Our Ref: EN010007

Planning Act 2008 (as amended) – Section 51

Application by Horizon Nuclear Power for an Order Granting Development Consent for the Wylfa Newydd Project

Advice following issue of decision to accept the application for examination

Scale	As Shown	Sheet Size	A0	(Sheets)	1 of 1
Drawing Number	WN0902-HZDCO-LPN-DRG-00002	Rev	3.0

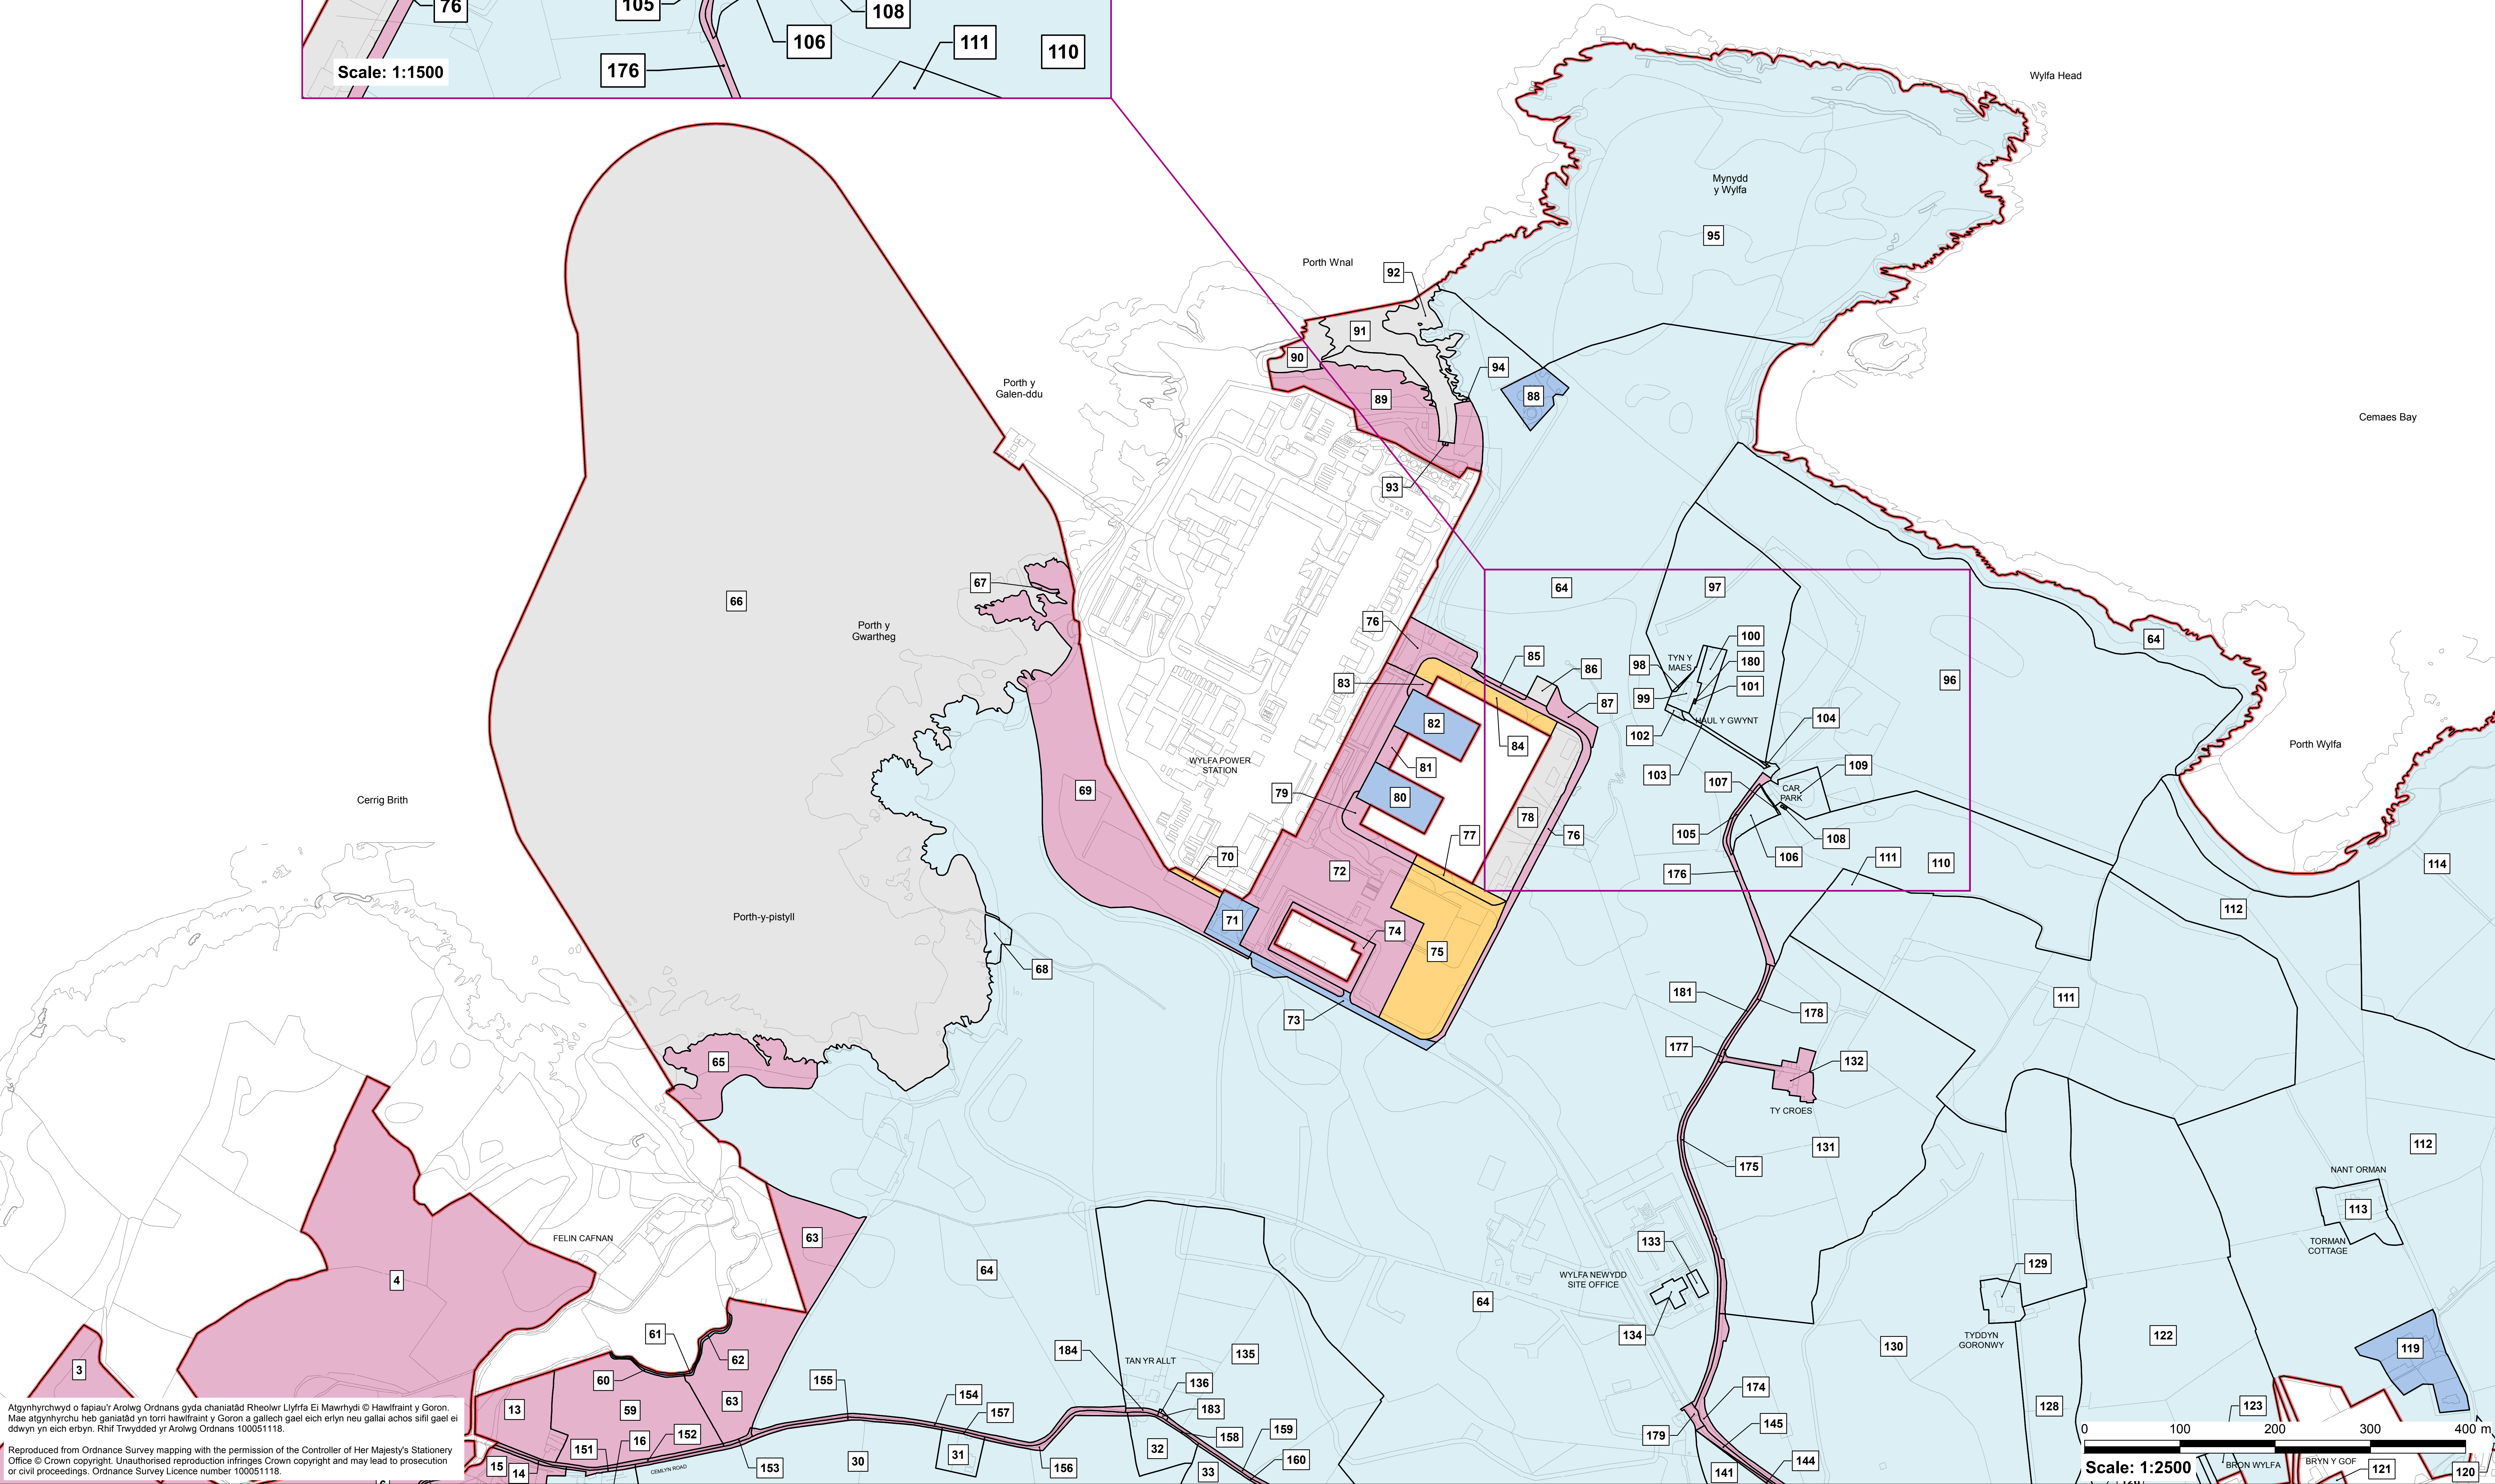
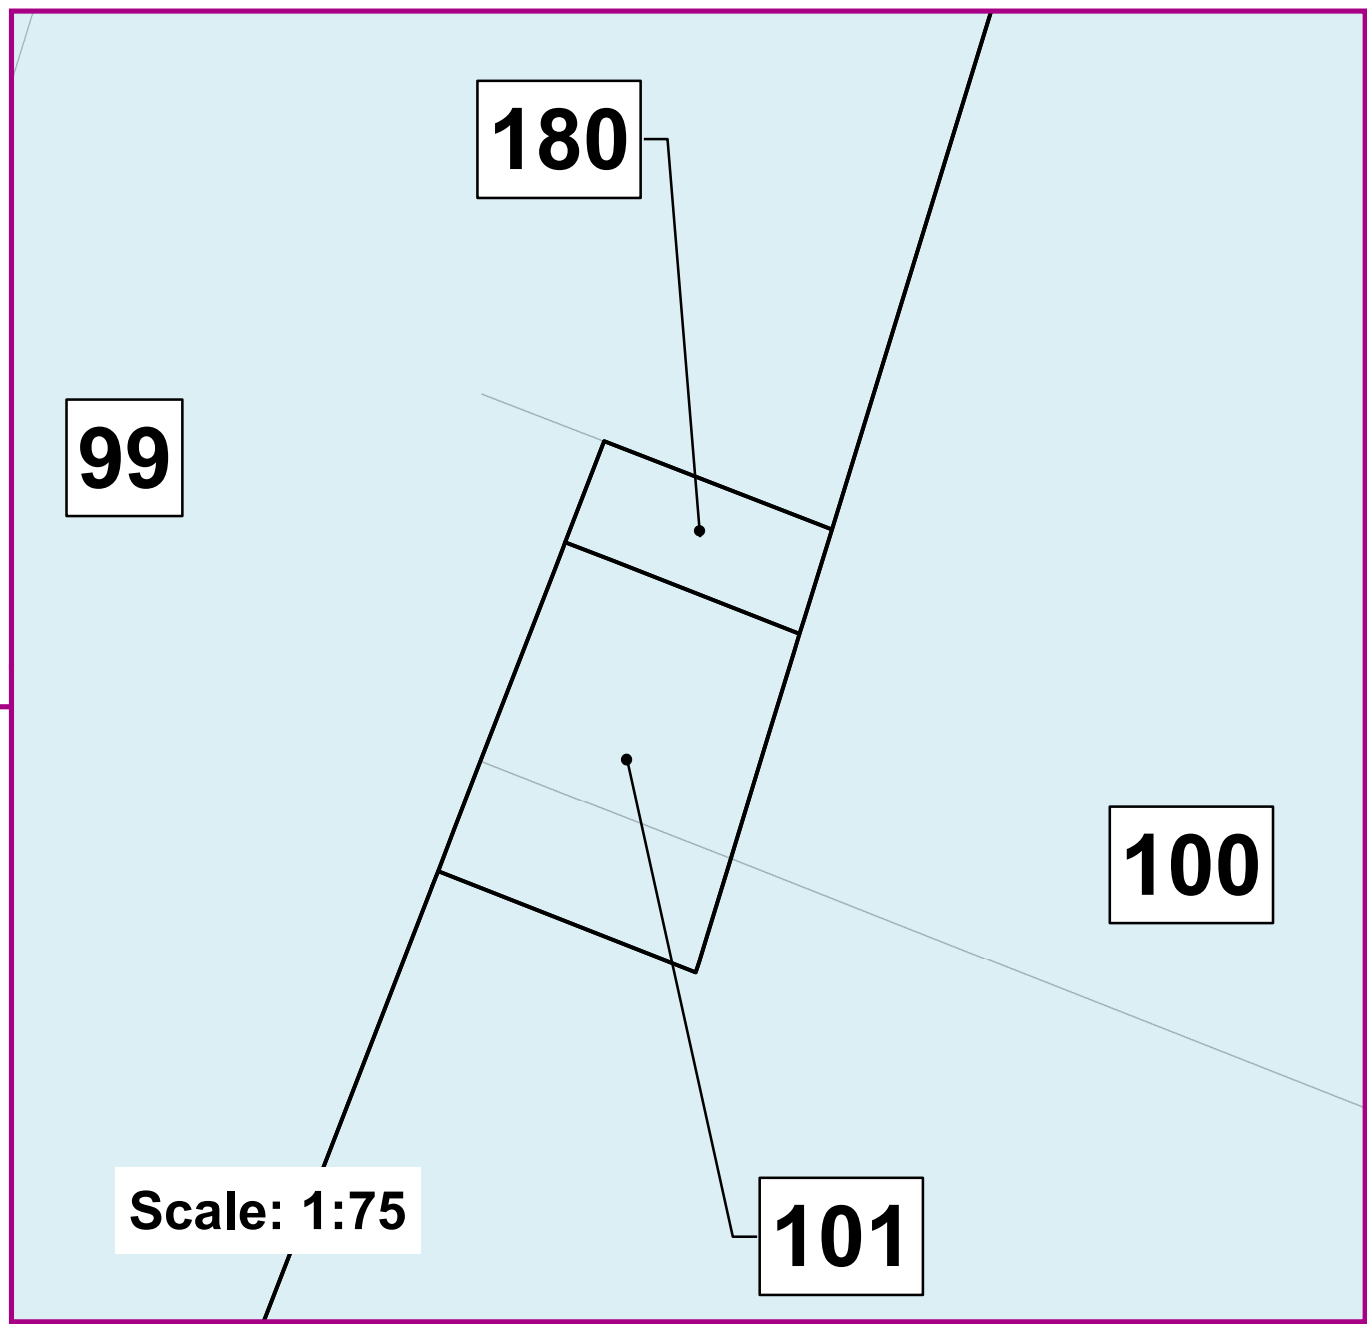
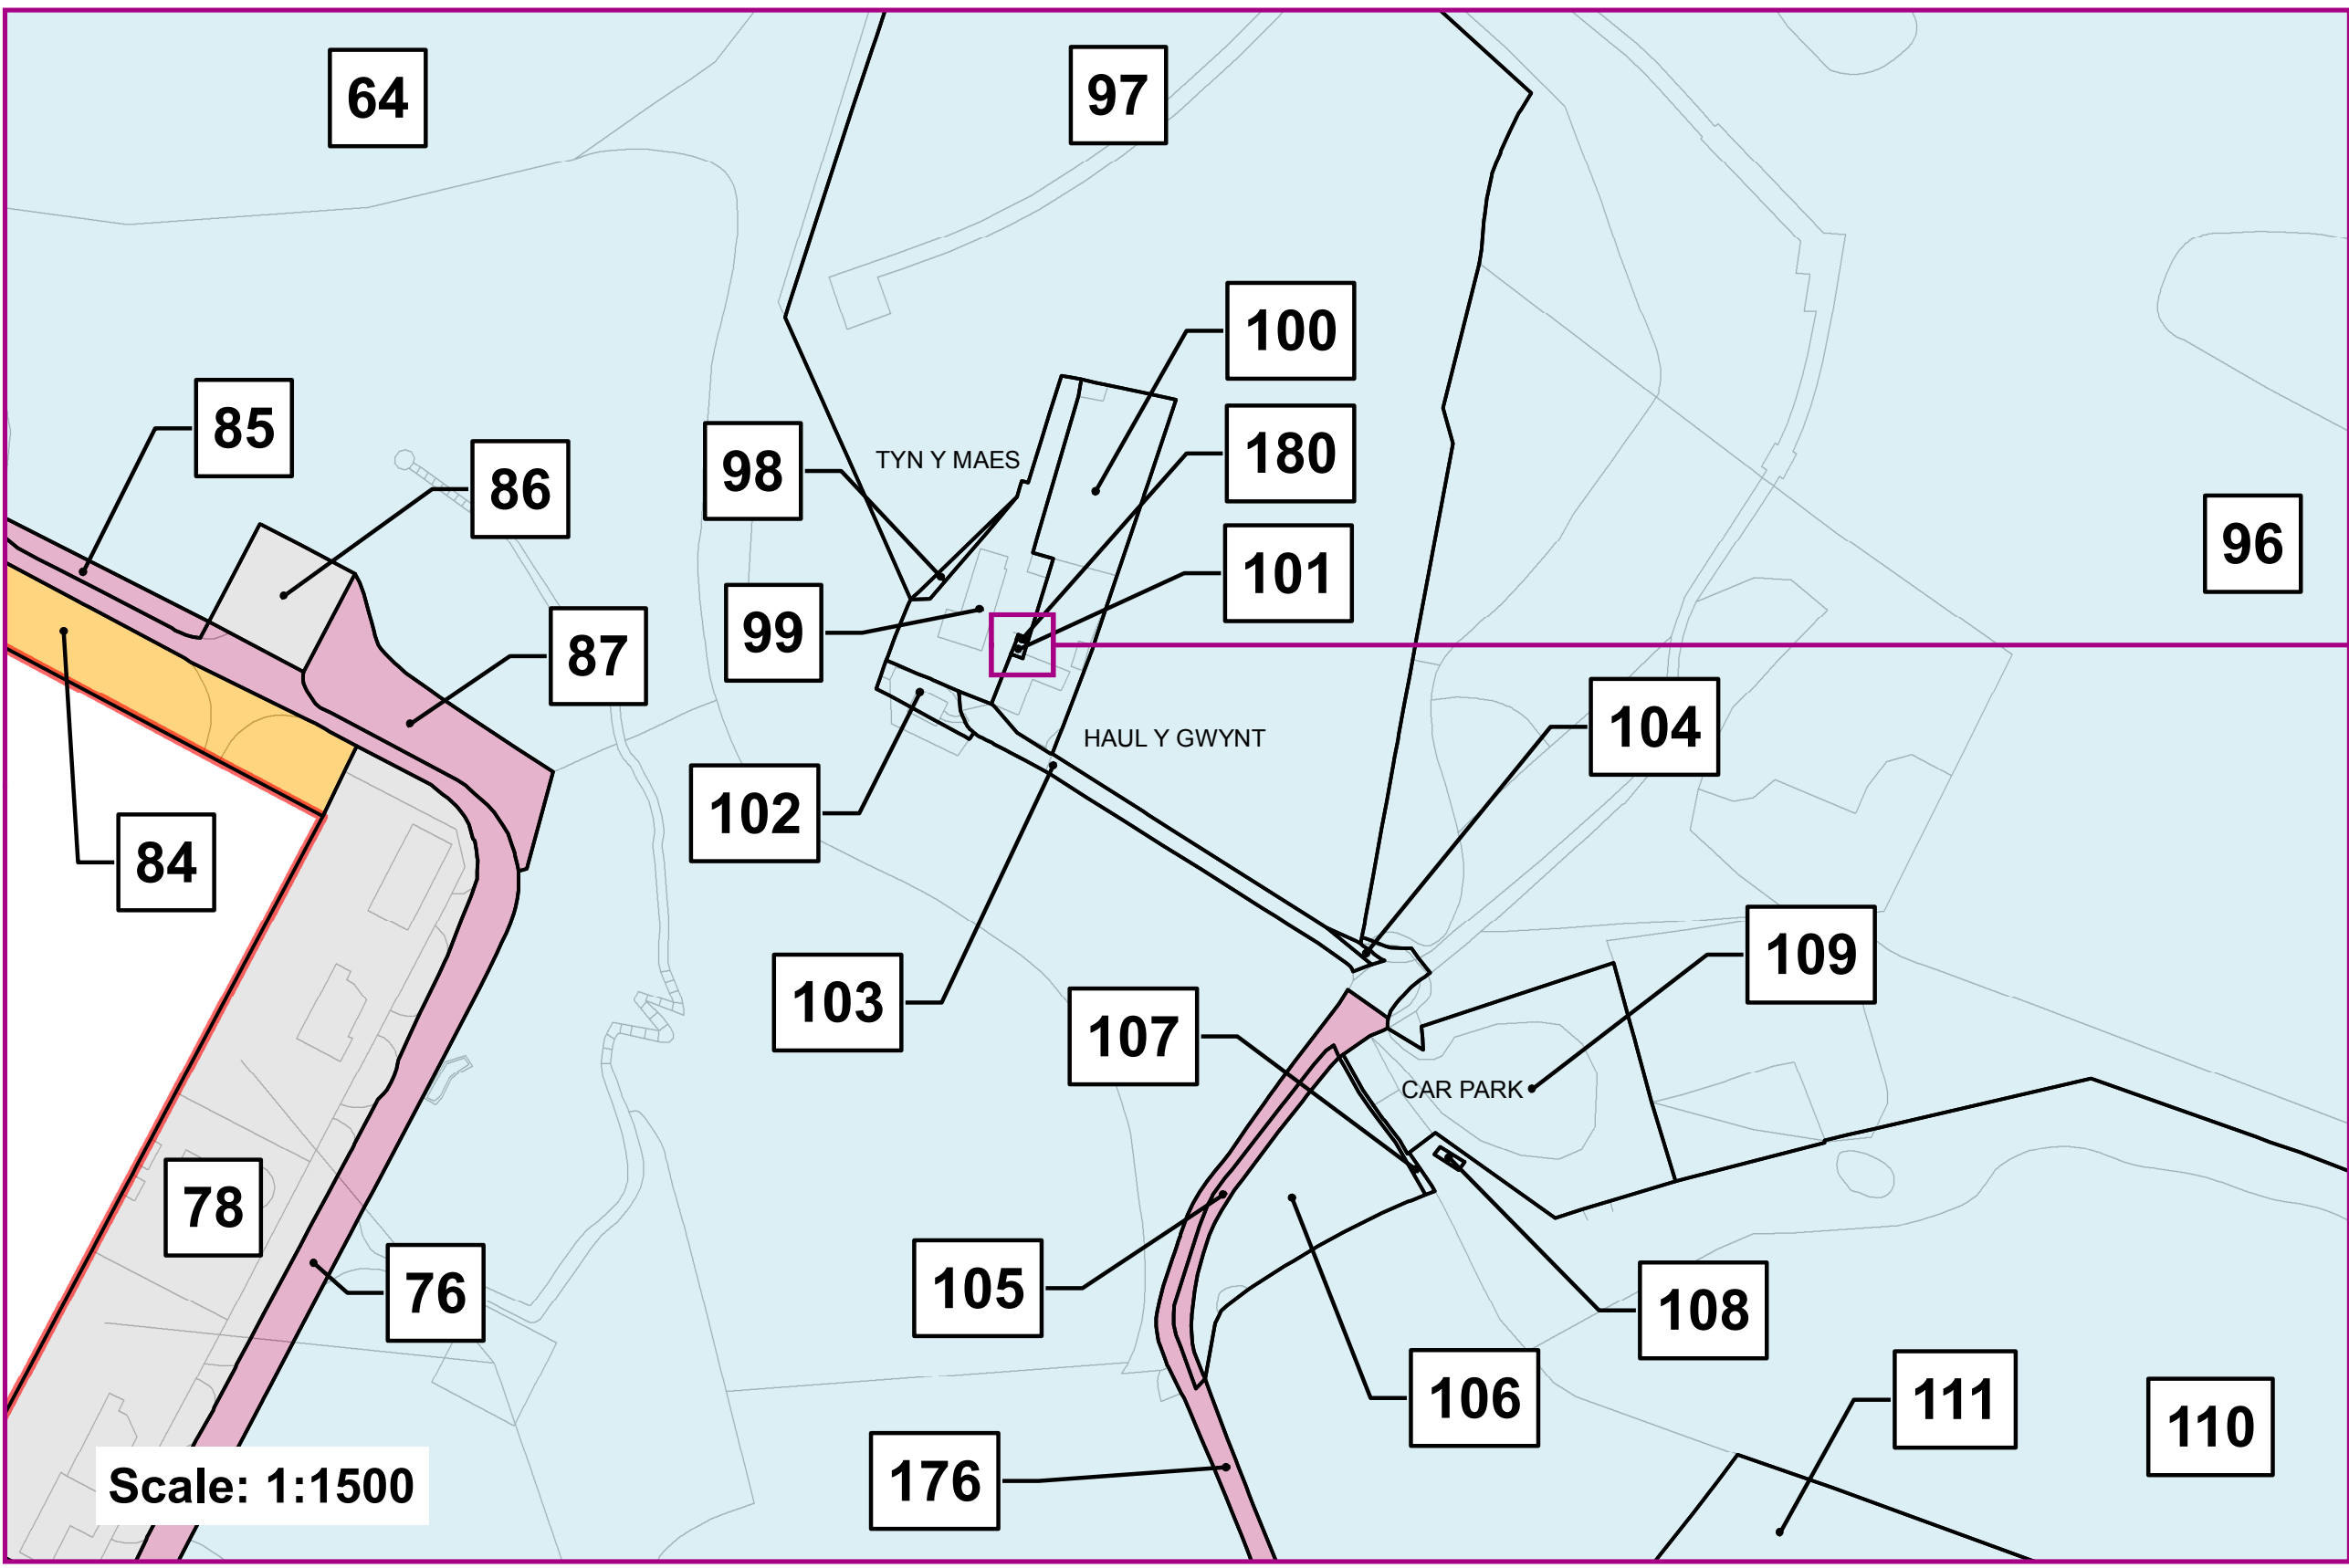
It is noted in the checklist (Box 30, Regulation 5(2)(i)) that there are some discrepancies in relation to the Land Plans. Further guidance on this issue can be found in DCLG's Planning Act 2008 Guidance related to procedures for the compulsory acquisition of land (Annex C).

Please provide updated Land Plans which include:

- A Legend consistent with the description as provided in the Book of Reference
- All relevant landmarks as described in Column 3 ('Description of Land') of the BoR for example A5025 highway, Tregle Service Station, Mynydd Ithel to be reflected on the relevant sheets associated to the Land Plans
- Inserts where plots are difficult to decipher
- A Legend that deciphers between the dotted, dashed and solid lines, and
- Ensure all plots are clearly identifiable and have a plot reference
